## Peppertree Quarry Modification 5

# ENVIRONMENTAL ASSESSMENT PRELIMINARY RESPONSE TO SUBMISSIONS

Prepared for Boral Quarries | February 2019

Figure 2

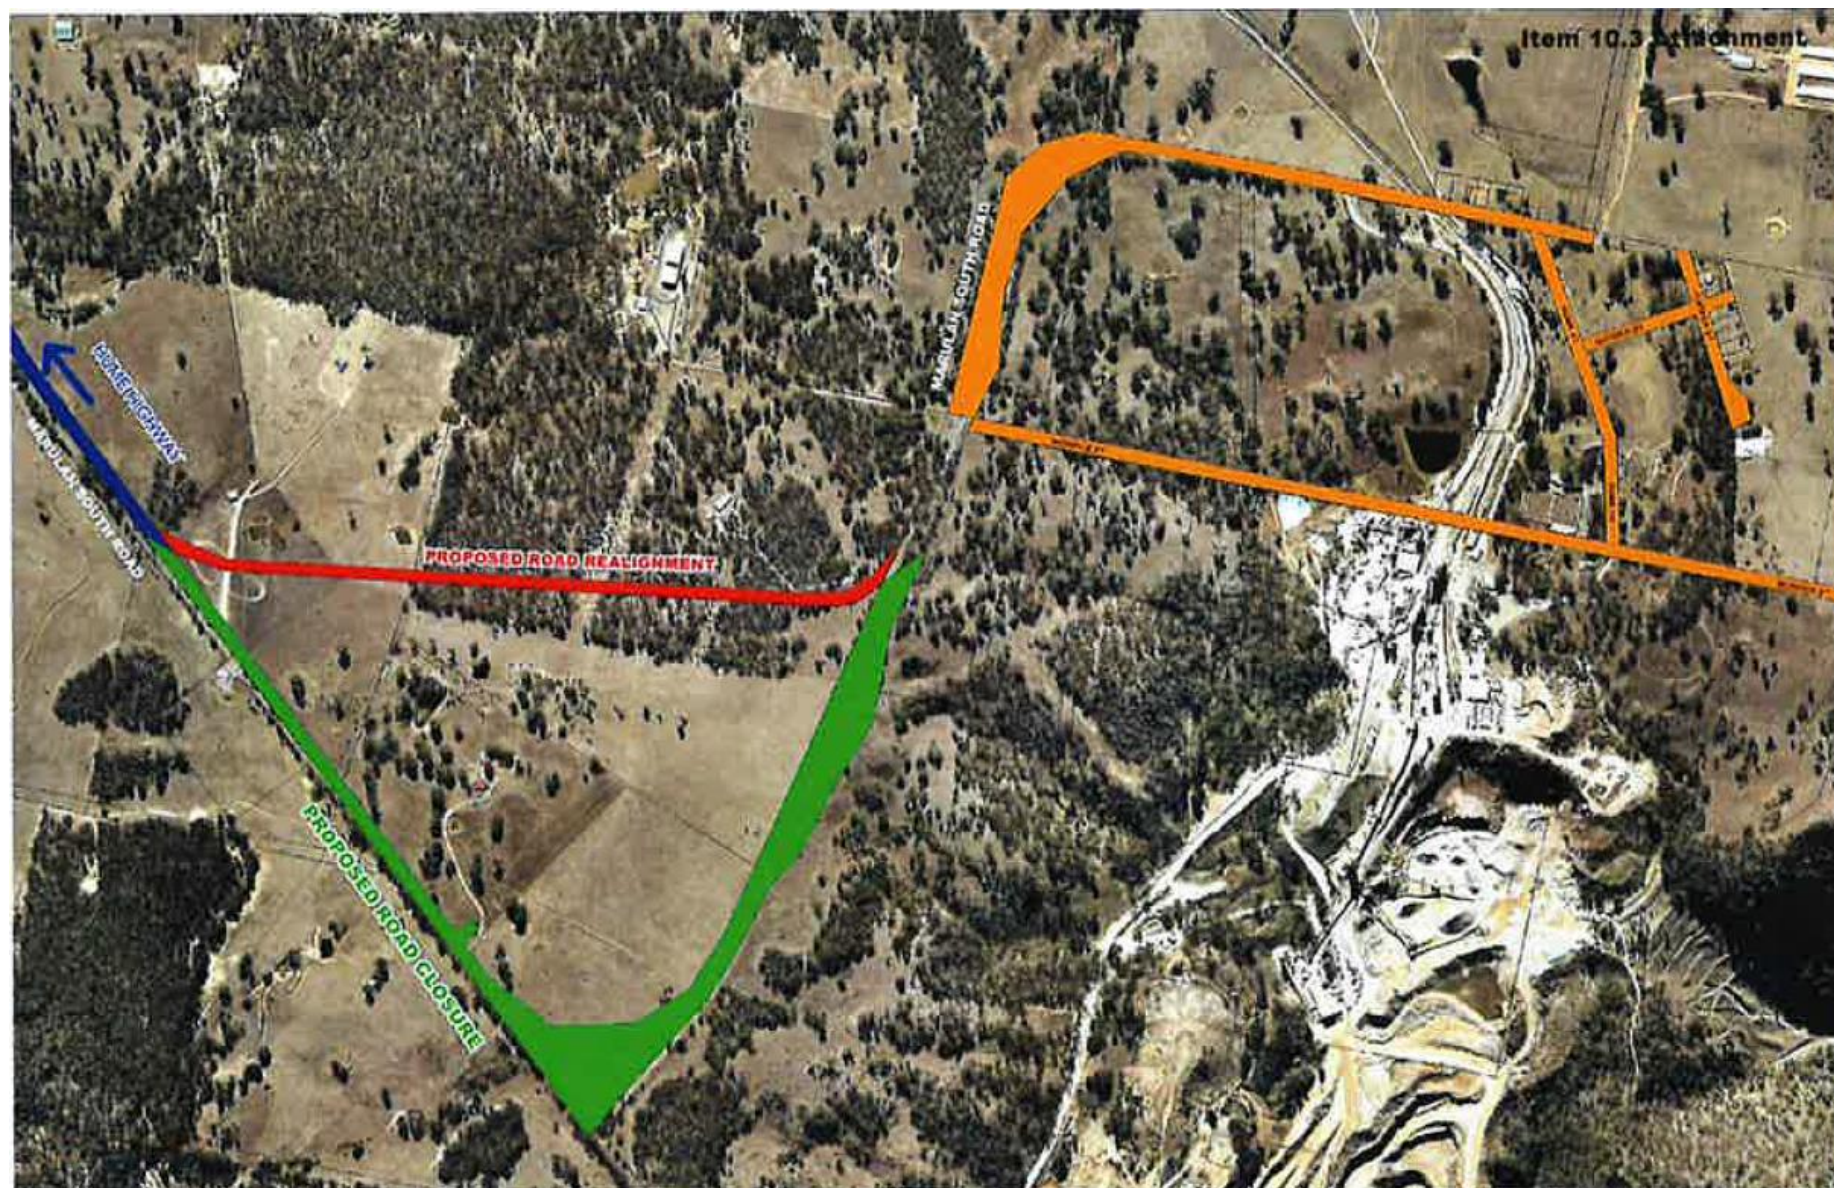
**If the road closure permits are not finalised before this road is operational the haul road will conflict with a public road (Refer Attached, Figure 2).**

Council's comments are noted. As set out in section 2.3.2 below, the road closure process is ongoing.

Boral is committed to concluding the Marulan South Road closure process prior to the start of haulage along the proposed haulage road.
